Please ask for: Ms Iqraa Malik
Email: iqraa.malik@terraquest.co.uk
Telephone: 01212341390
Our Ref: AW/294/20/HH
Your Ref:
Date: 3rd November 2020

Application for Planning Permission for Works or Extension to a Dwelling

Development: 2 storey side extension
Location: 2 Robins Drive Aldwick PO21 3BL

Proposed rear elevation

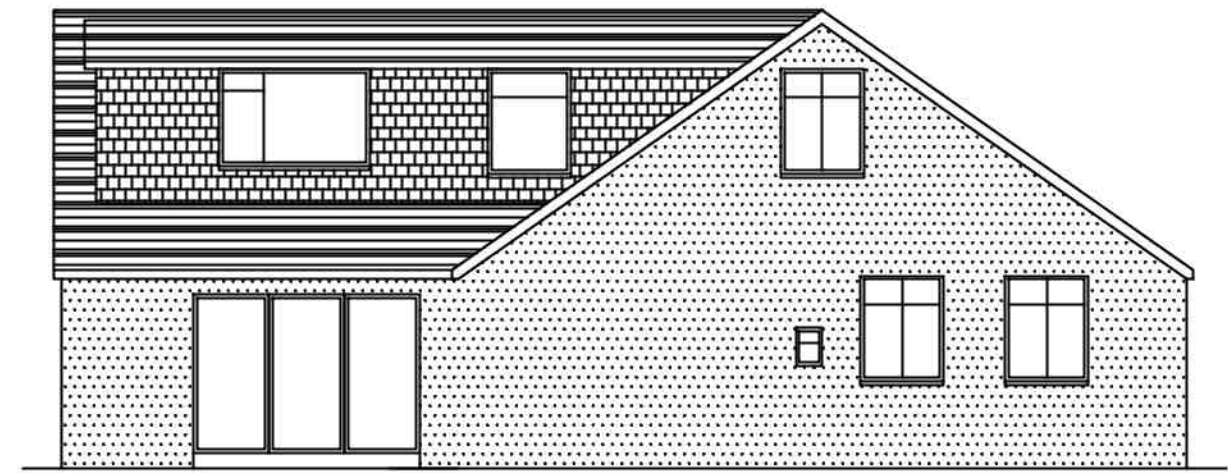
Proposed Rear Elevation

The building line on the proposed rear elevation is inconsistent with the ground floor plan submitted. Along with this, the small window on the rear elevation is missing from the ground floor plan. Please amend.

Proposed side elevation
(Remains unchanged)

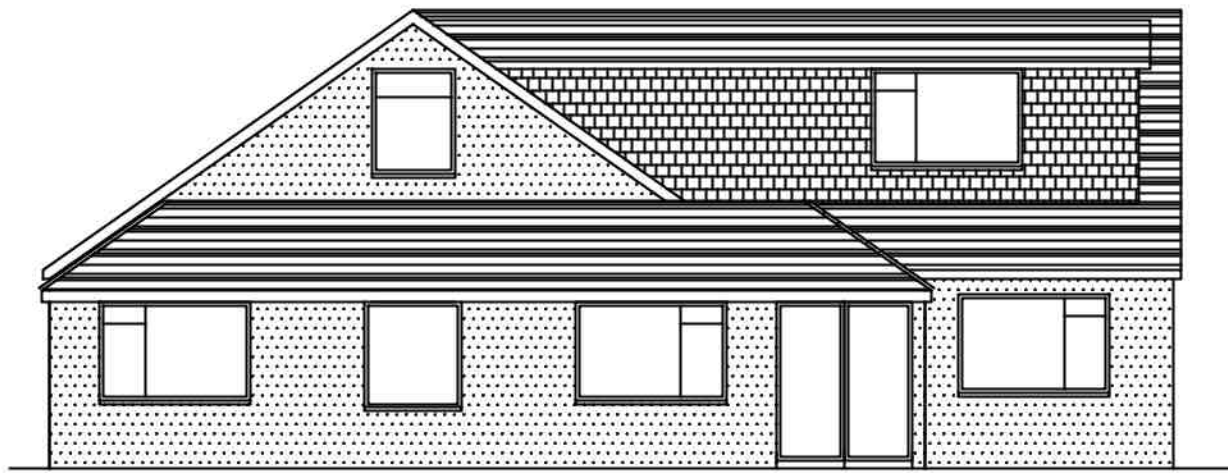
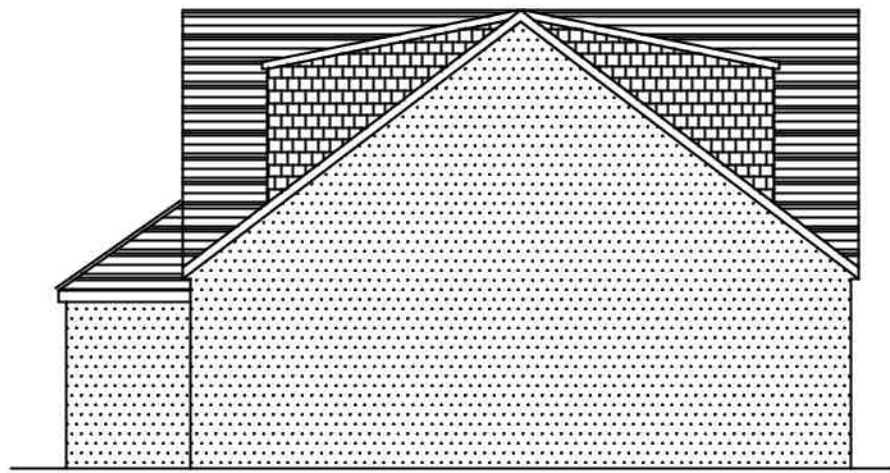
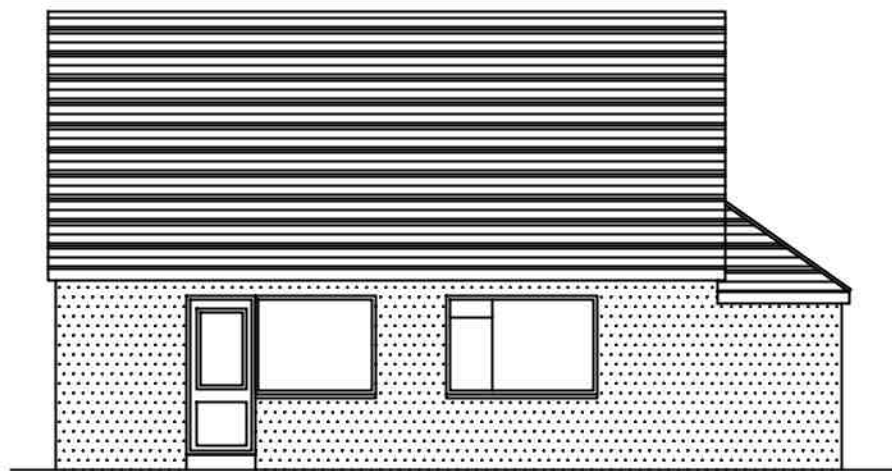
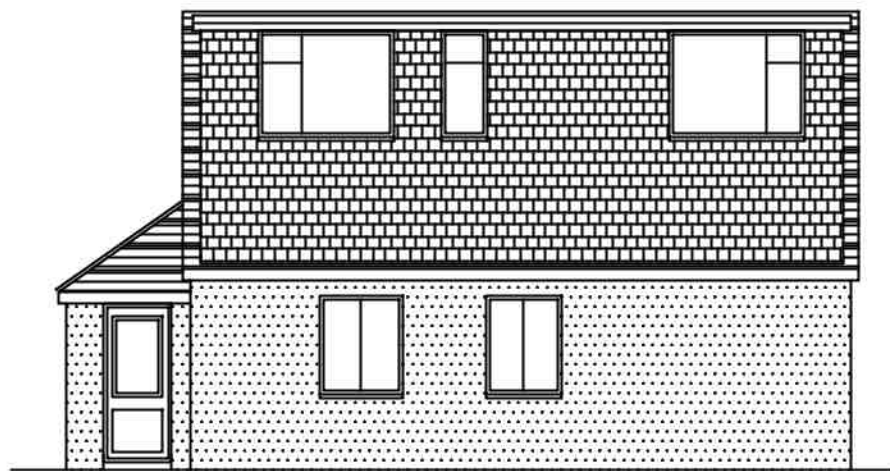
Existing and Proposed Side Elevations

The building line on the existing and proposed side elevation which remain unchanged is inconsistent with the floor plans submitted. Please amend.

PROPOSED SITE PLAN - 1 : 500

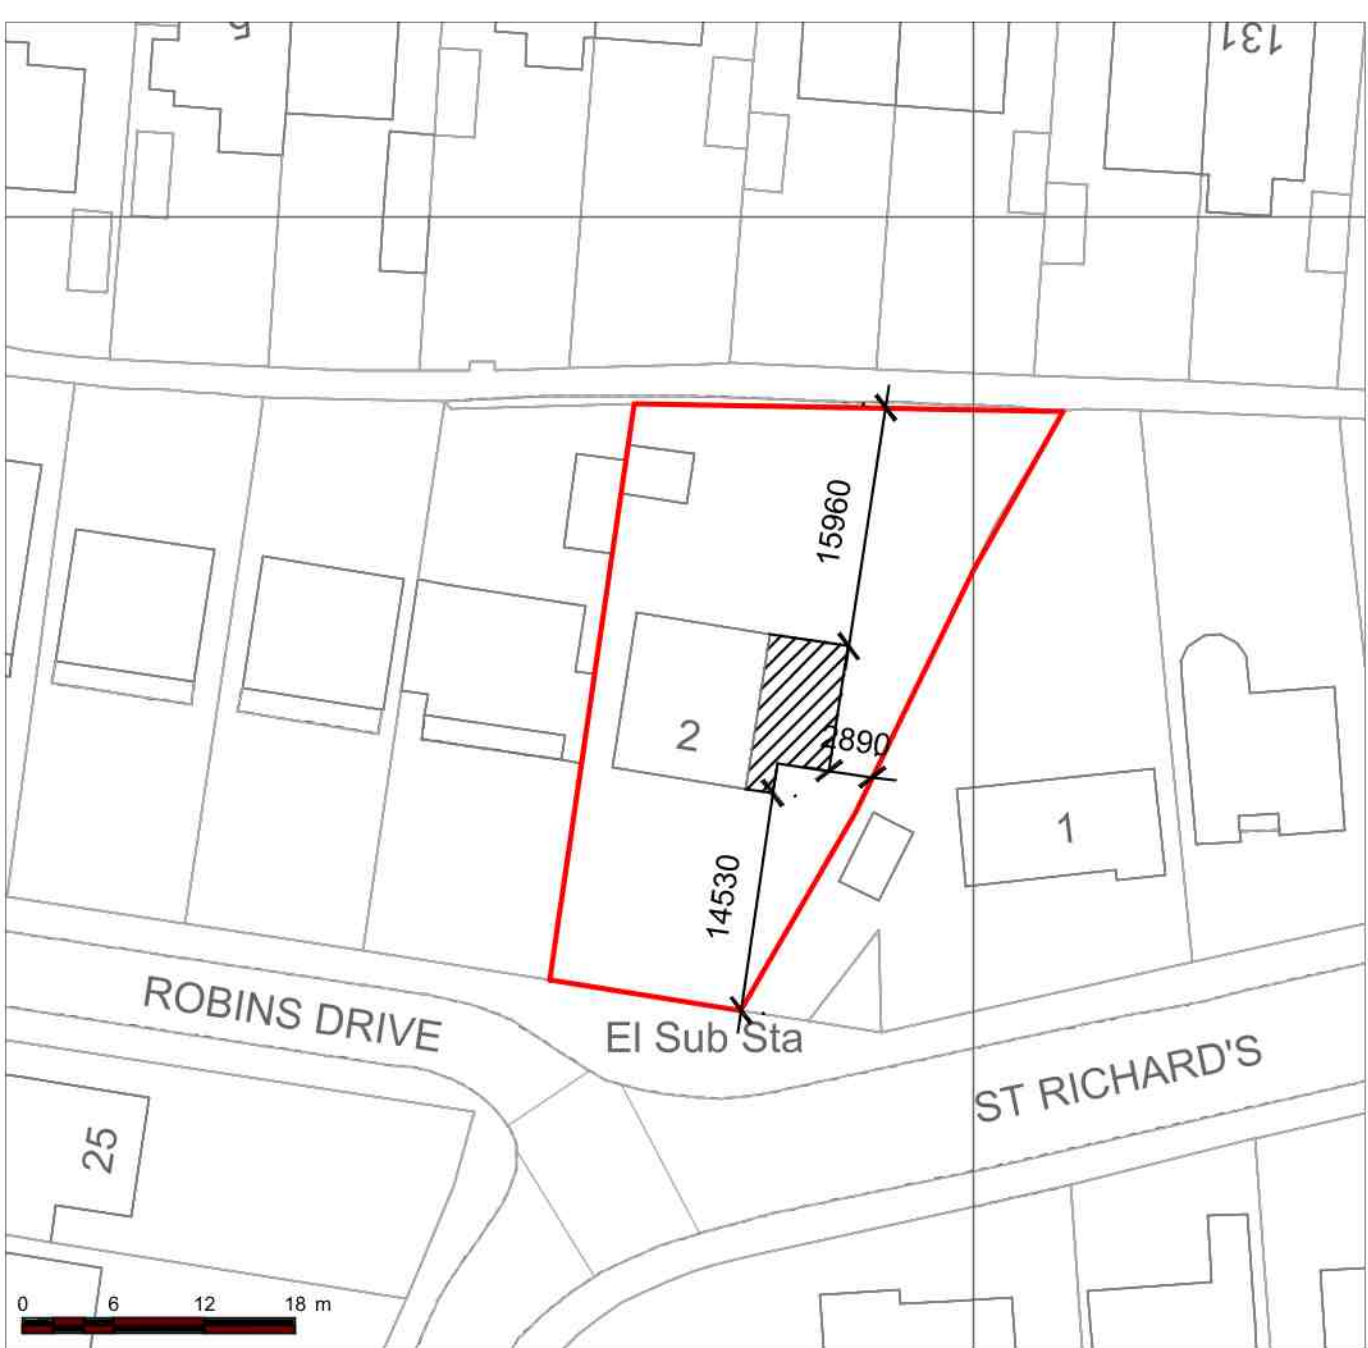
Block Plan

You are required to have dimensions from the proposed extension(s) to all site boundaries. Please amend.
